Your Ref: OWPC14900
Our Ref: A/121/17/HH 21-06-2017
Please ask for:
Mrs A Gardner

Detached double garage & single storey extensions to existing garage.
Harcourt West Drive Angmering

Thank you for your internet representation made on 3rd August 2017 which has been recorded as '**an objection**' with the comments as follows:

<table><tr><td>PROJECT HARDCOURT West Drive, Angmering Littlehampton. BN16 4JE</td><td rowspan="4"> 29 Breach Avenue, Southbourne, Emsworth, Hampshire. PO10 8NB T: 01243 697164 M: 07879471666 www.pdkconsulting.co.uk</td><td rowspan="4"> PDK Architecture and Surveying</td></tr><tr><td colspan="2">DRAWING PROPOSED SITE PLAN</td></tr></table>

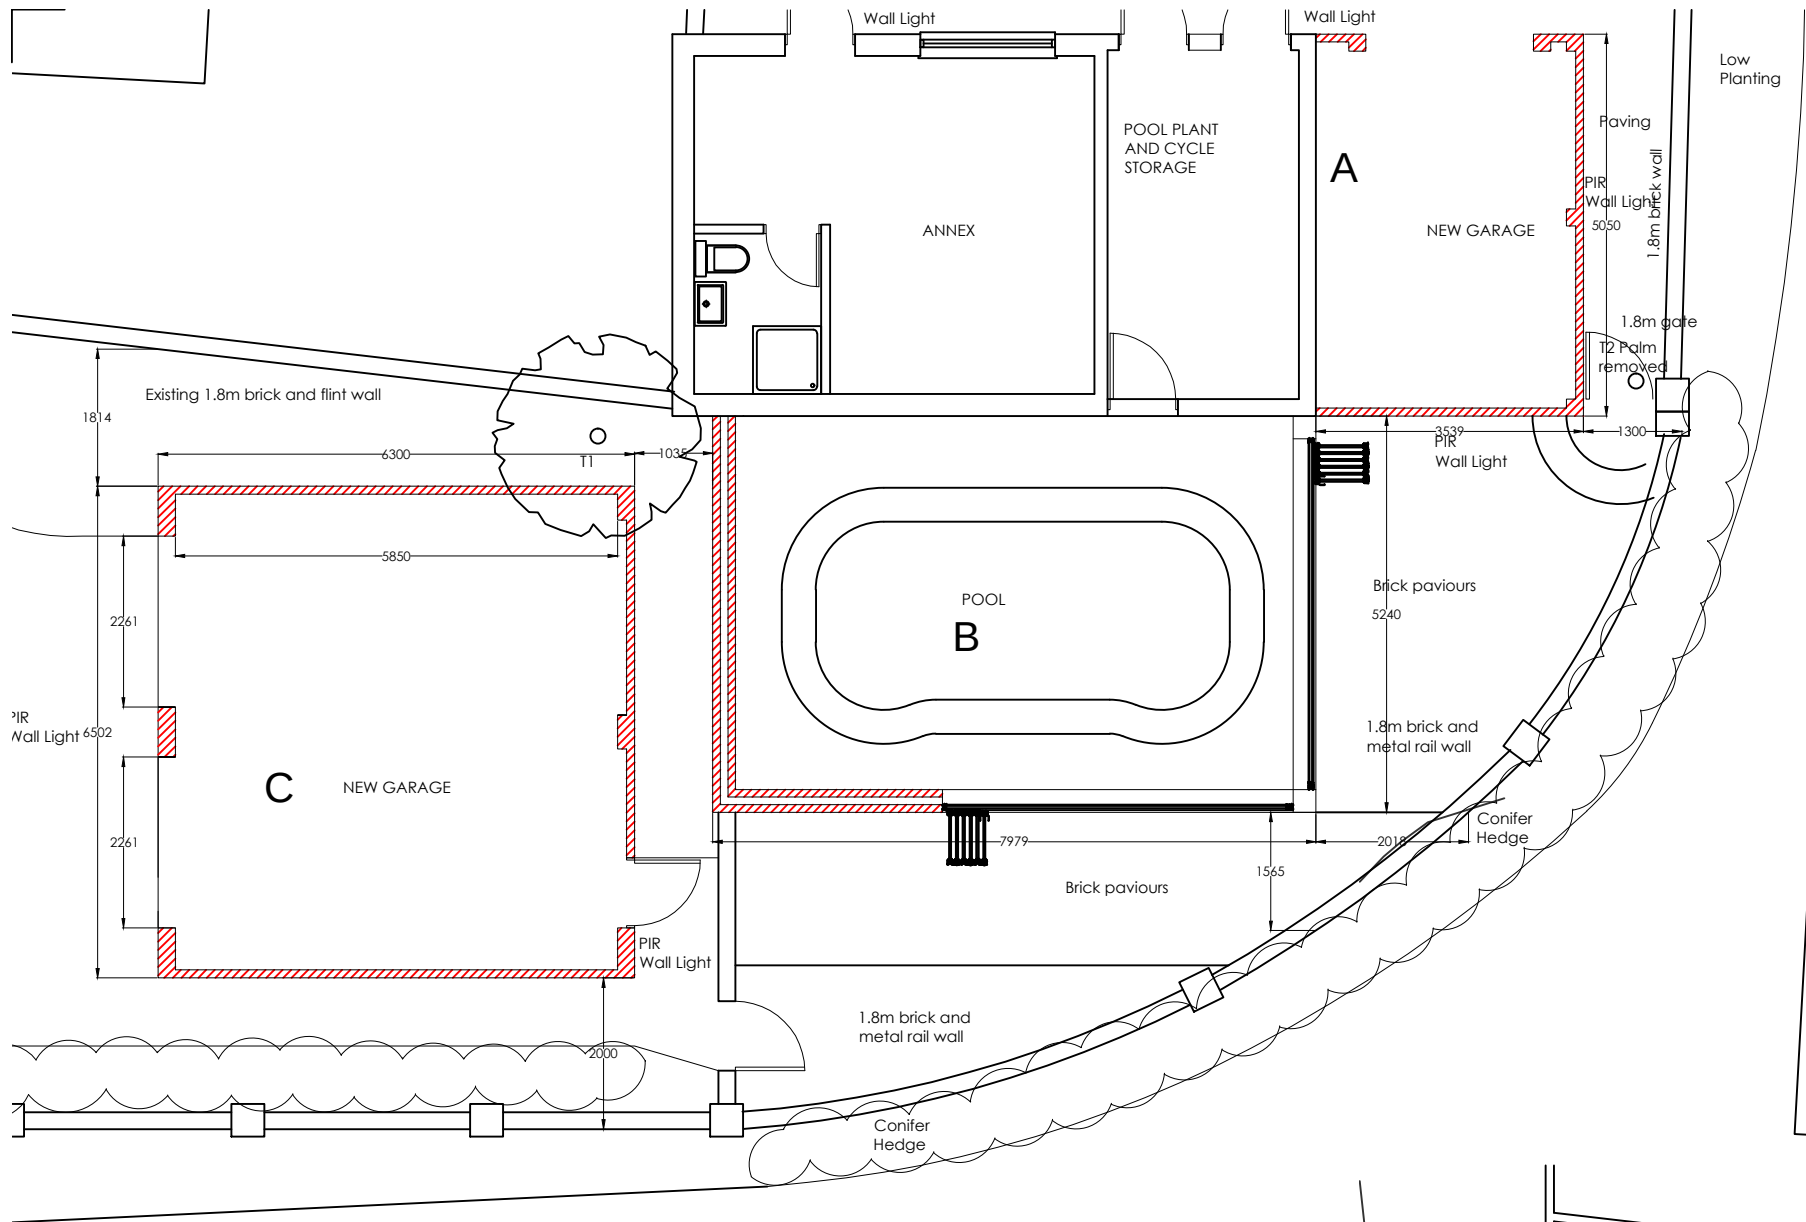
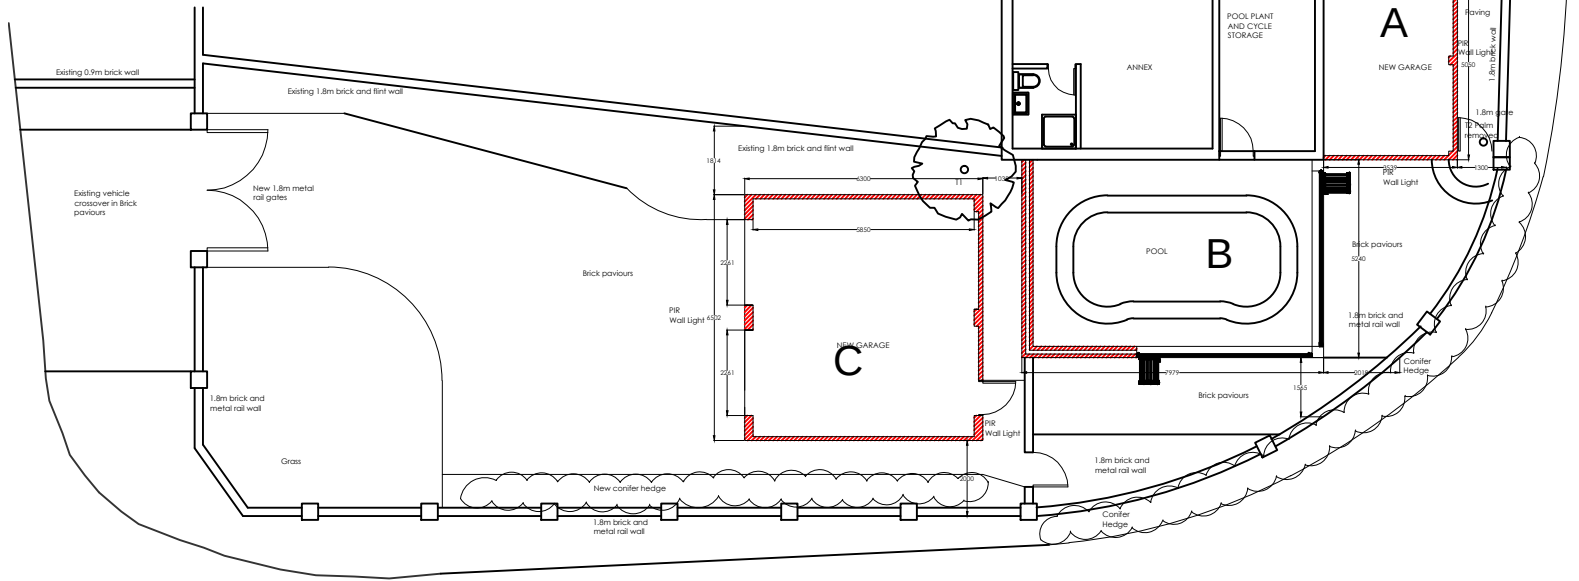
Now the current application is to effectively build a double garage with a forecourt that will presumably allow for additional exterior parking for at least four cars. Plus an extension to create a third Garage.
